CITY OF ALBUQUERQUE

**RE: Golf Course & Westside Commercial Development
Grading & Drainage Plans and Drainage Report
Engineer's Stamp Date: 03/29/23
Hydrology File: A12D008B2**

**RE: GOLF COURSE & WESTSIDE COMMERCIAL DEVELOPMENT
GRADING & DRAINAGE RESPONSE TO COMMENT**

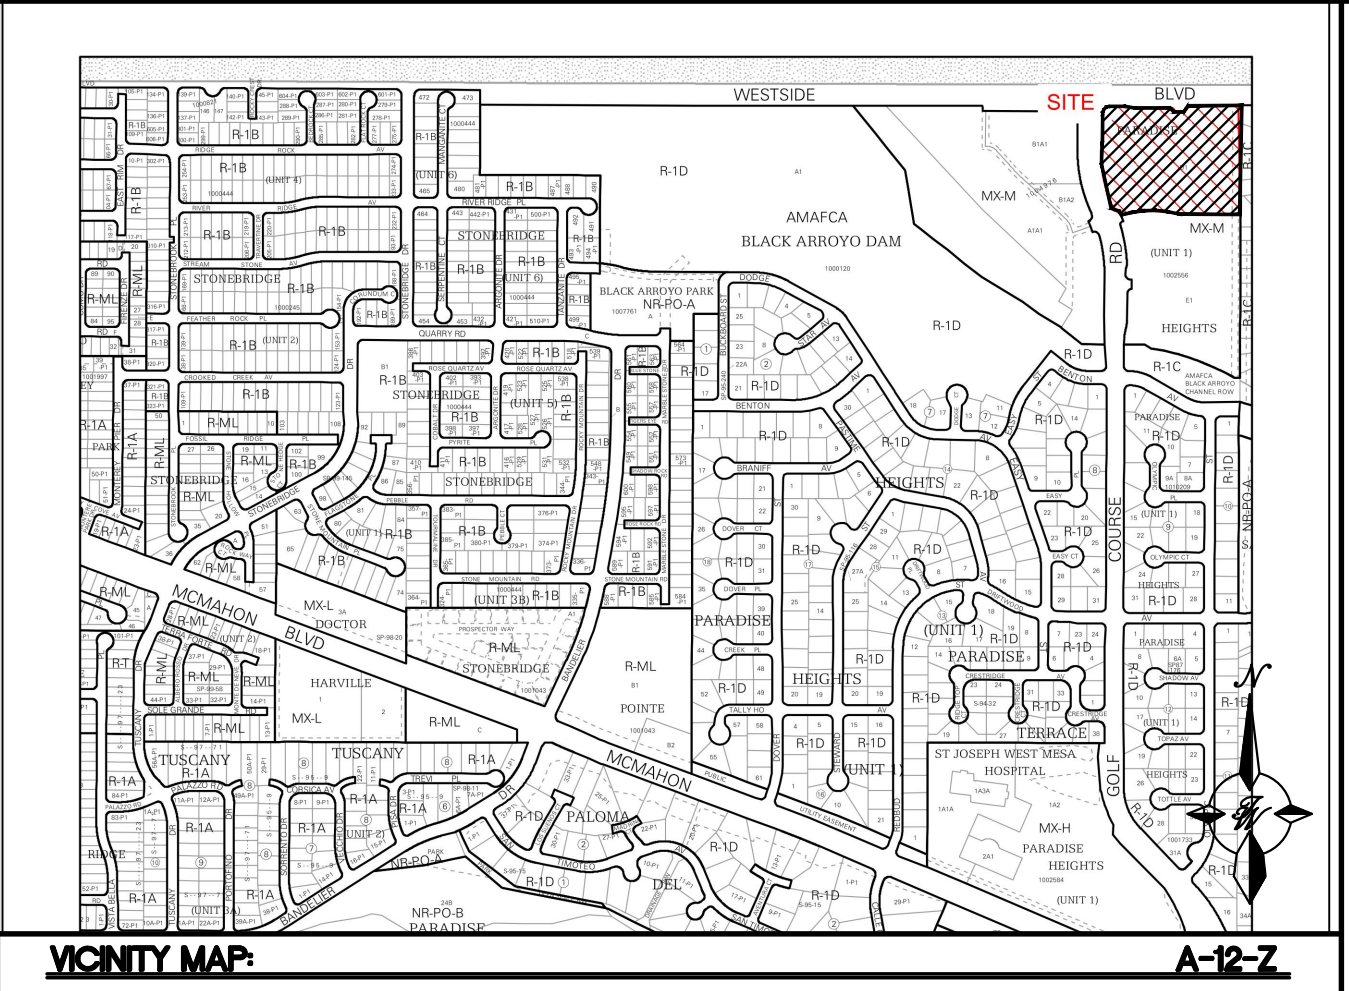
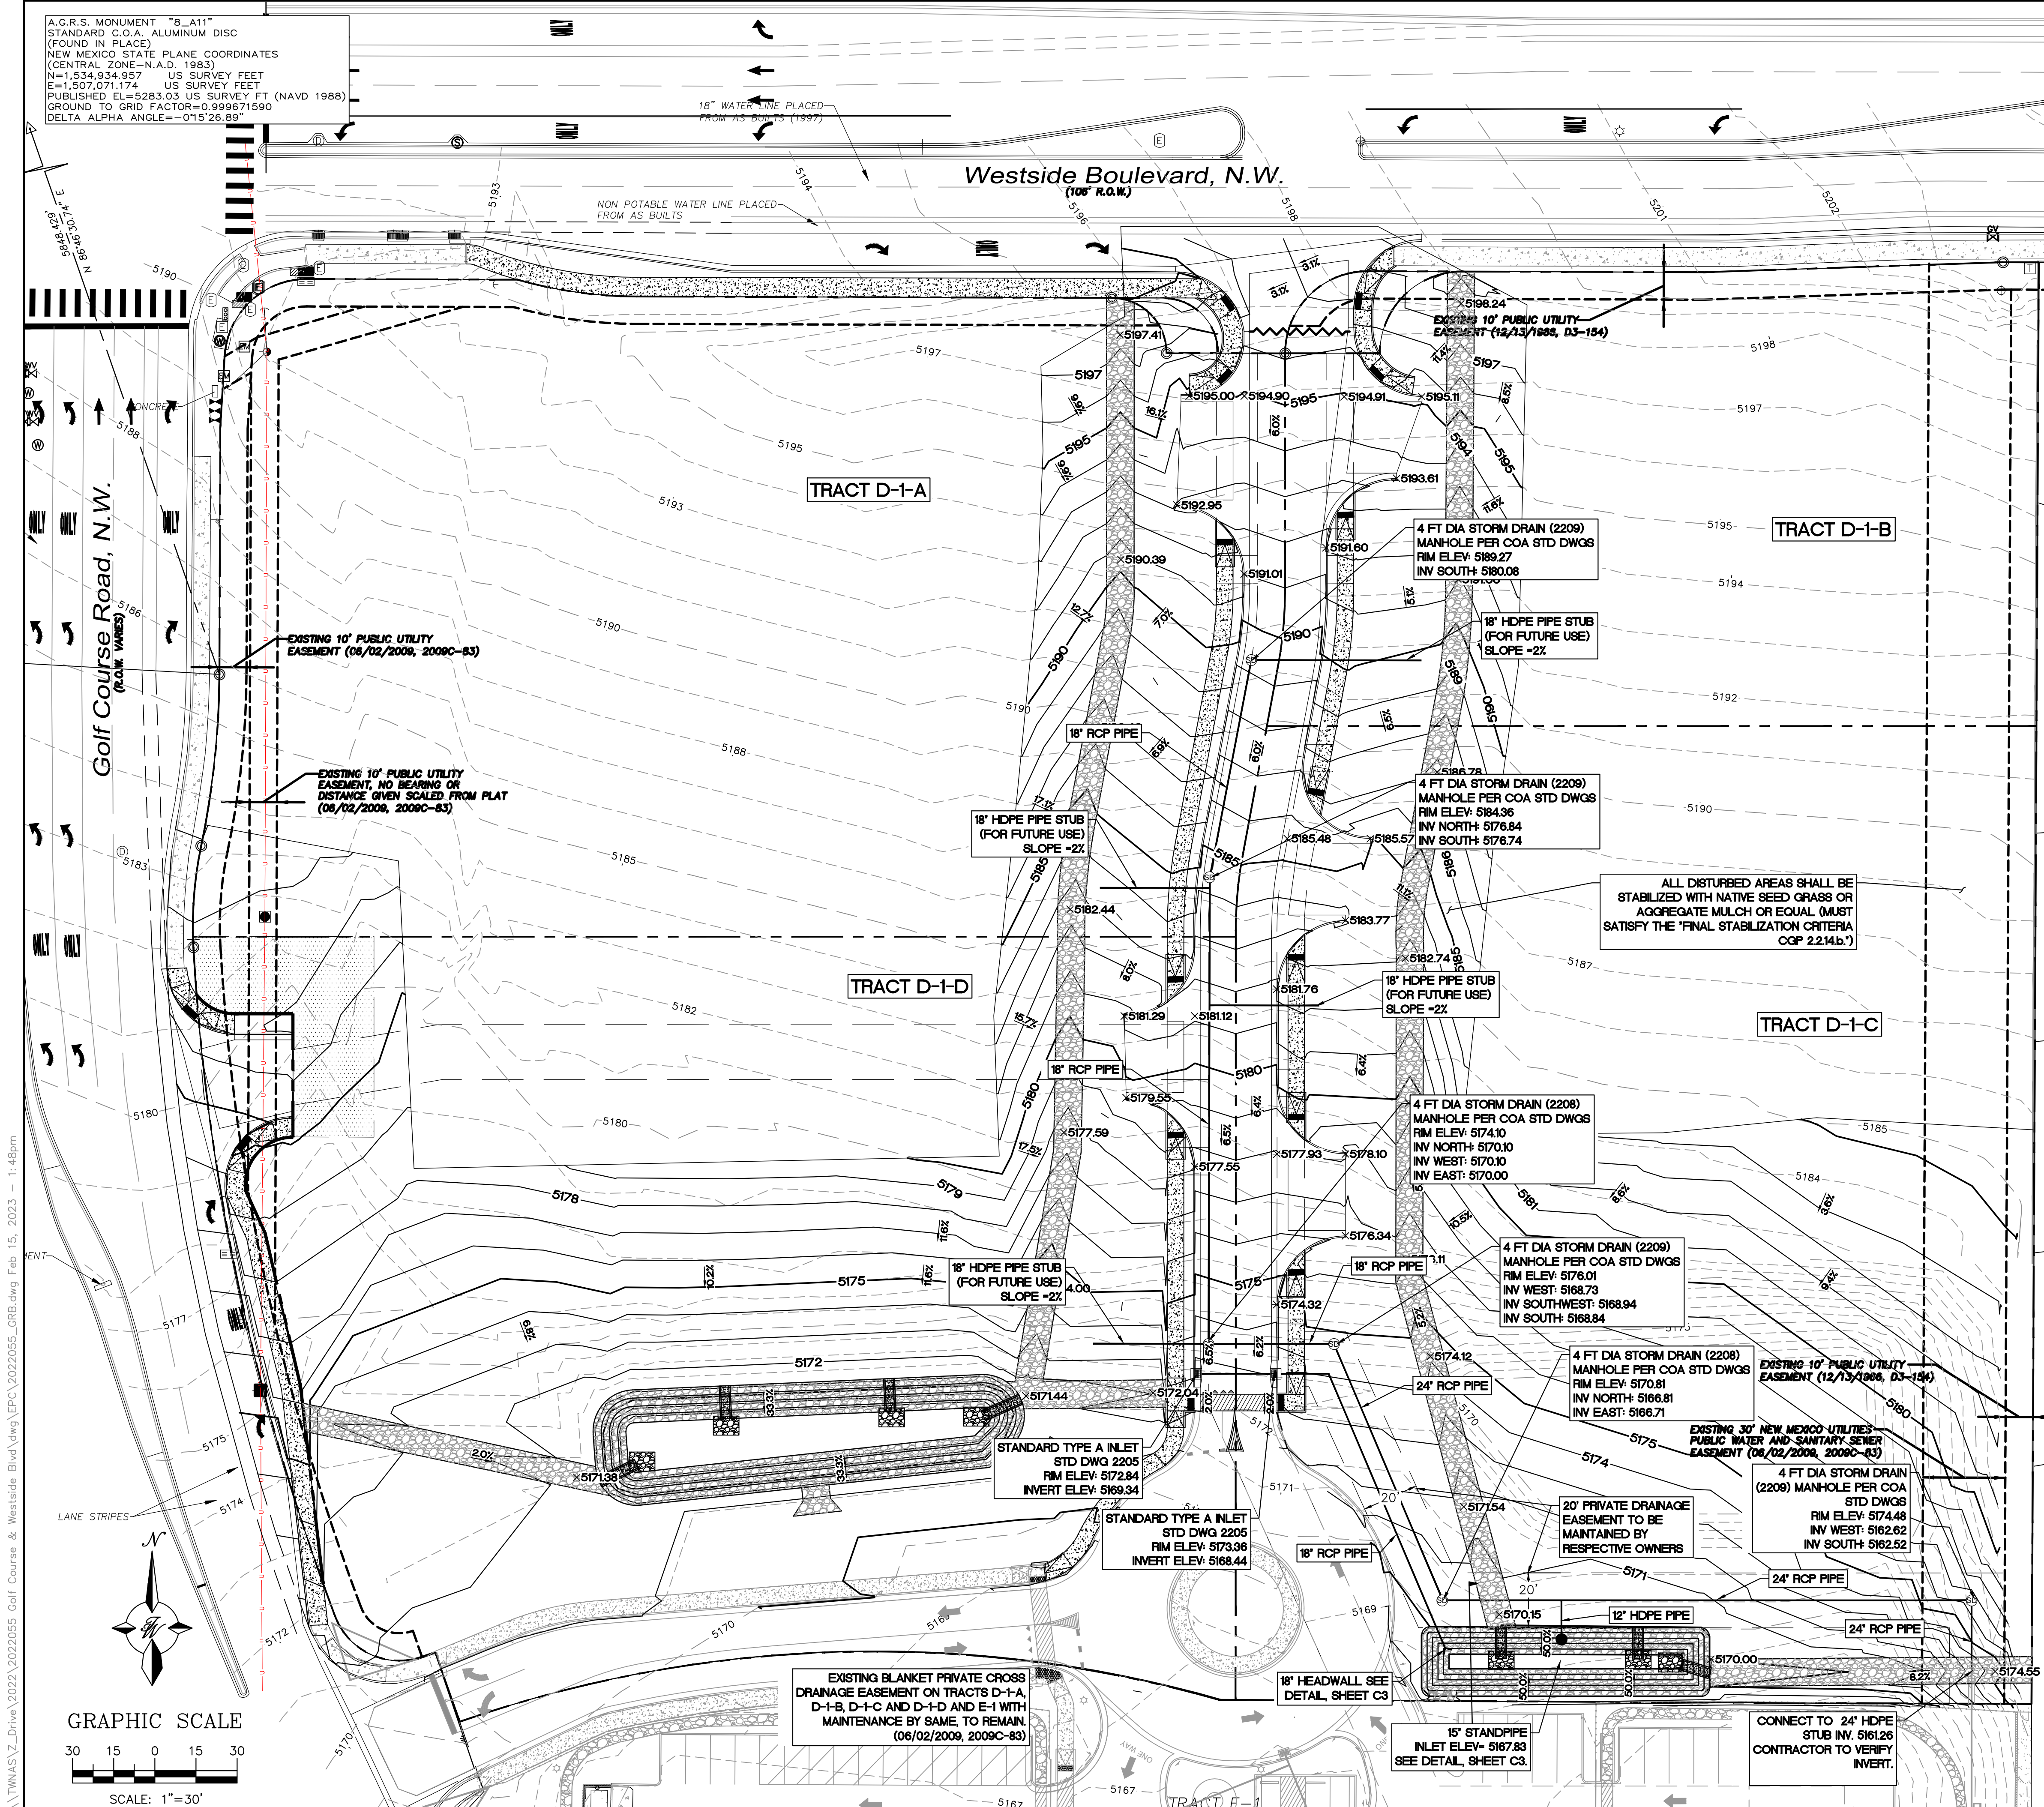
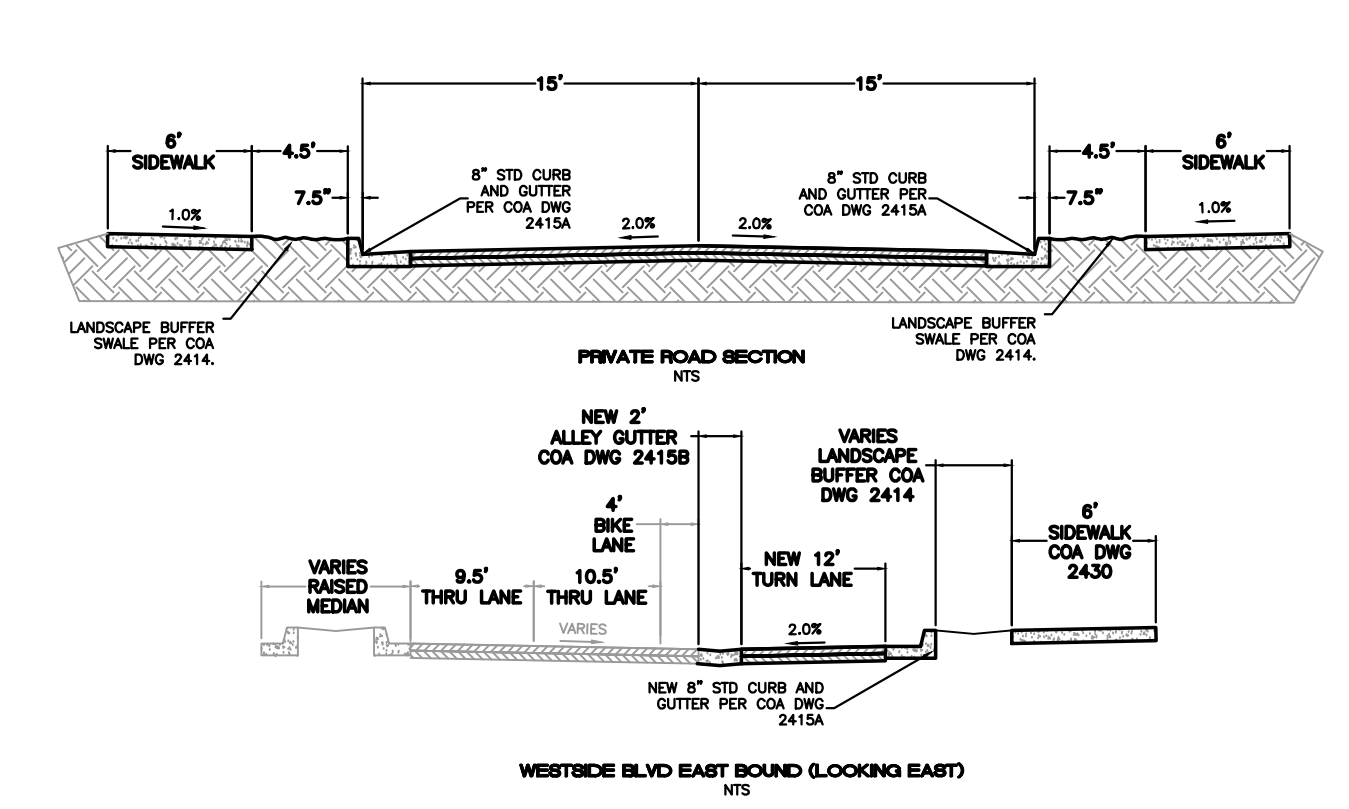
1. The overall drafting needs some serious attention. There are existing easements with labels that are too thick in pen width. These need to be shaded back.

Response: Acknowledged, existing easements shaded back.
2. There are proposed easements which just face into the background. These needs a little bit more pen width to them.

Response: Added pen width to proposed easements.
3. It appears that the entrances for Tracts D-1-A & D-1-B are too close to Westside Blvd. Please check with Transportation Section to verify the distance requirements.

4. Please make all drives perpendicular to the private drives or public streets. There are several that are askew and need to be fixed.
Response: Curb cuts were updated to be more perpendicular to the street.

5. The proposed sidewalk in this area appears not to conform to construction conventions. Please verify with the Transportation section.
Response: Sidewalk at this location was updated to conform with construction conventions.

6. All the storm drain within the development is private. There are call outs for HDPE and then there are call ours for RCP. Since this is all private storm sewer, please stick with only one material type.

Response: All storm drain pipe material was updated to HDPE.
7. All stub outs should be only 5 feet beyond the proposed sidewalk and should have a plug with an inv elevation.

8. Depending on the material that is to be used, please fix the stub out connections, If RCP is to be used, then you will need manholes for the connections. If you use the HDPE, then that is not needed since they do make Tee connections. If HDPE is to be used, please ensure that the tee connections are at least 5 feet from all manholes and inlets for buildability.

Response: Per DPM Section 7-4(B)(4) Vehicular access section the minimum distance between site access and intersection is 75 ft, driveways were shifted to meet requirements.

Response: Stub outs updated to be 5 feet beyond the proposed sidewalk with end caps and invert elevations are called out.

Response: Since the proposed pipe material is HDPE all tee connections are either manhole connections or 5 ft from a manhole.

GOLF COURSE + WESTSIDE ALBUQUERQUE, NM	DRAWN BY RG
	DETAILS	DATE 02/15/2022
		2022055_GRB
	 5571 MIDWAY PARK PLACE NE ALBUQUERQUE, NM 87109 (505) 858-3100 www.tierrawestllc.com	SHEET # <b>C3</b> JOB # 2022055

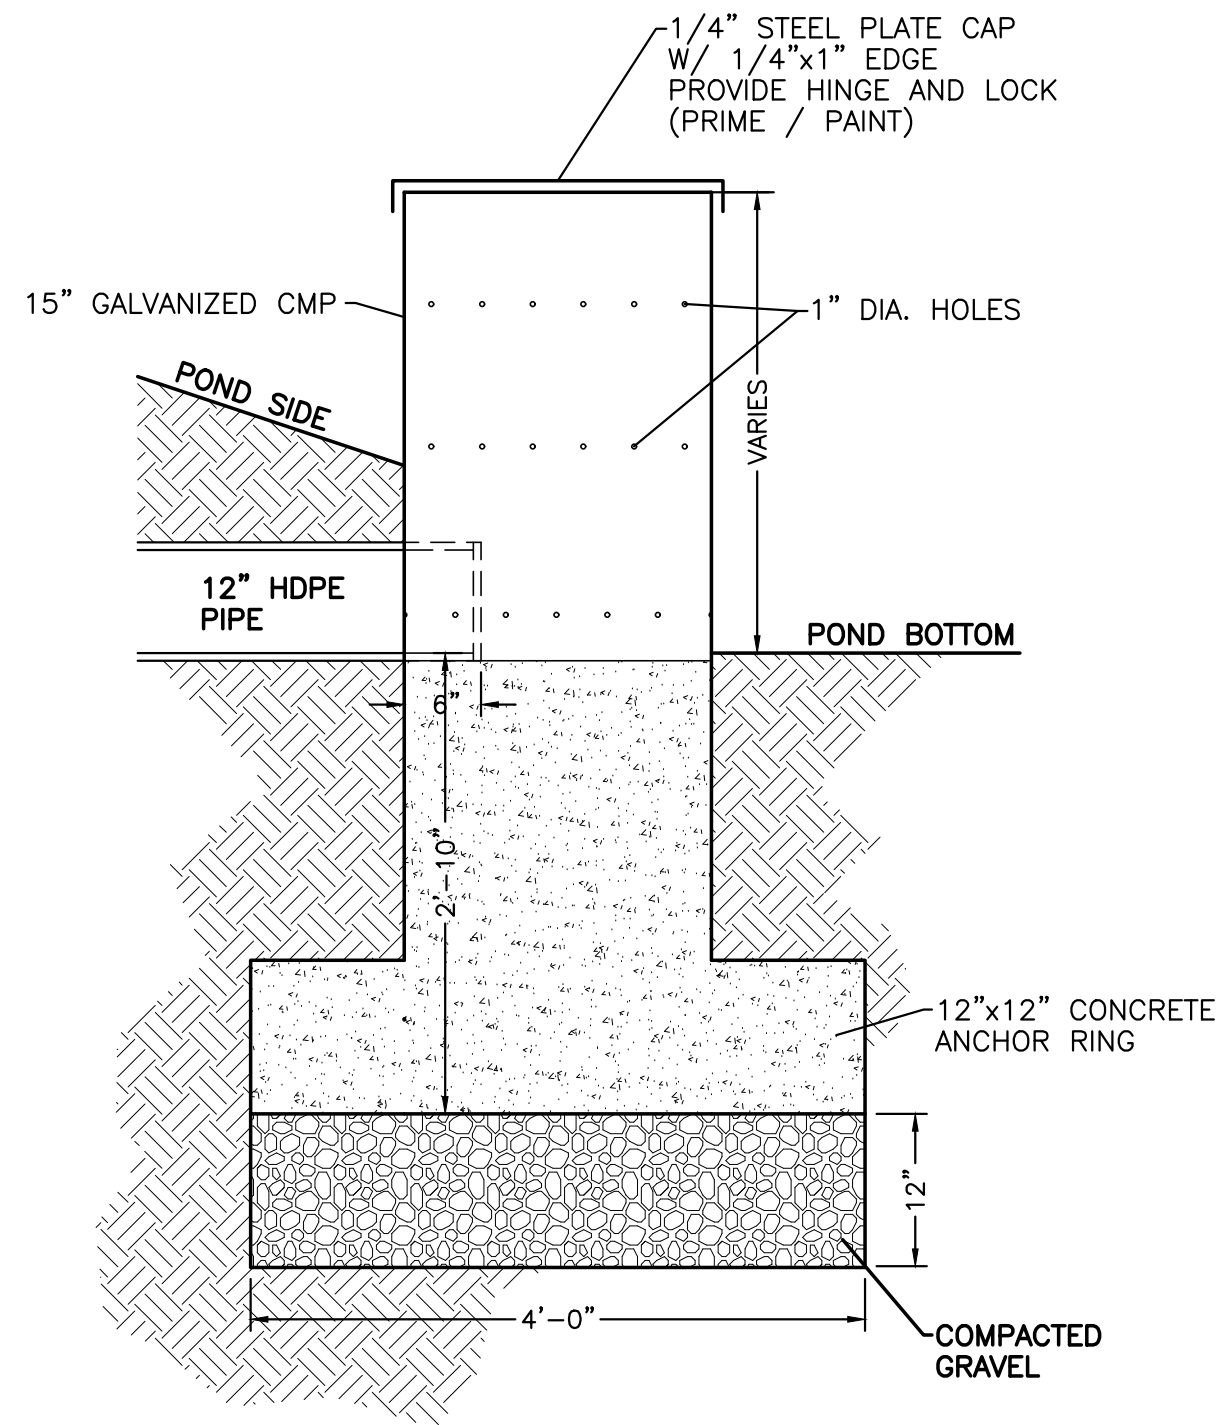
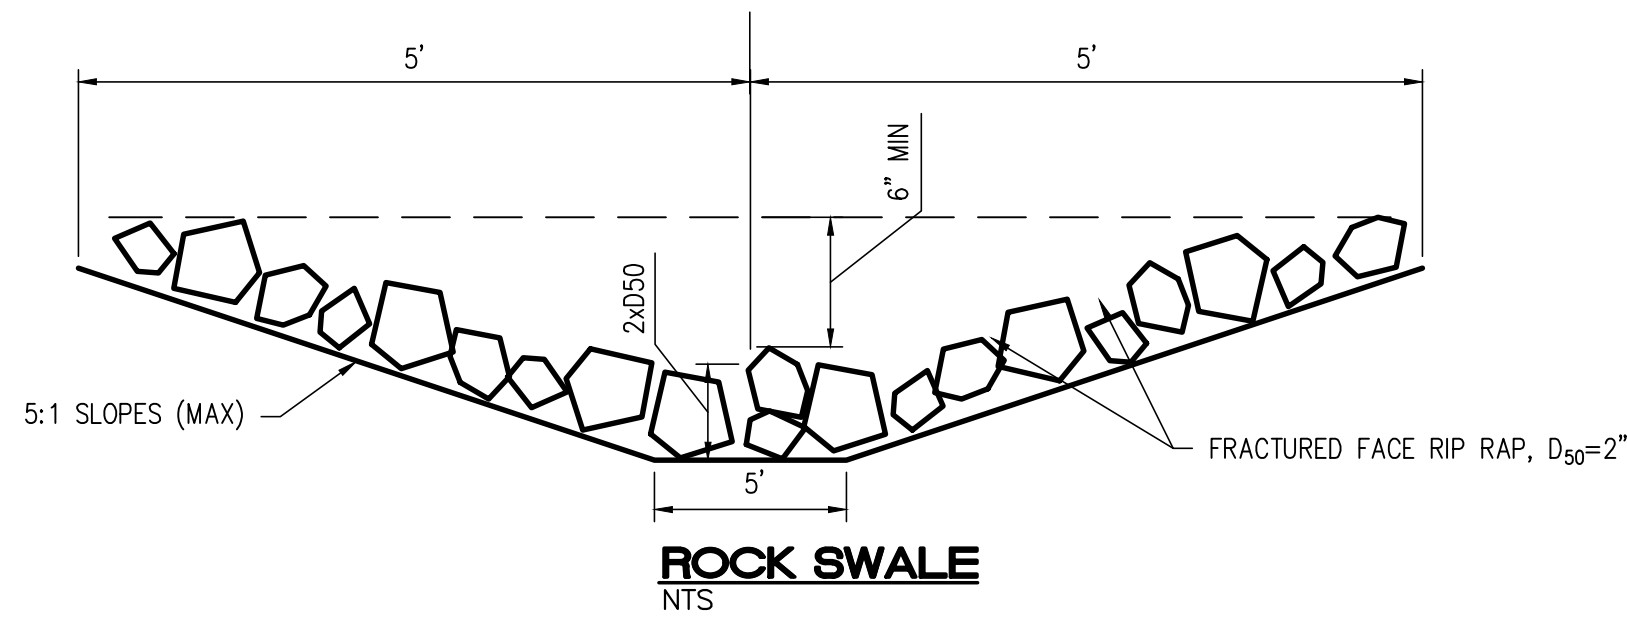
9. The proposed stand pipe will not function as shown. It needs to be at the bottom of the detention pond in order to work since the 1' dia holes will be drilled 360 degrees around the pipe. Also, the detail has information missing in order to build it as designed.

Response: The proposed stand pipe riser detail was updated to work under the specific site circumstances and constraints.
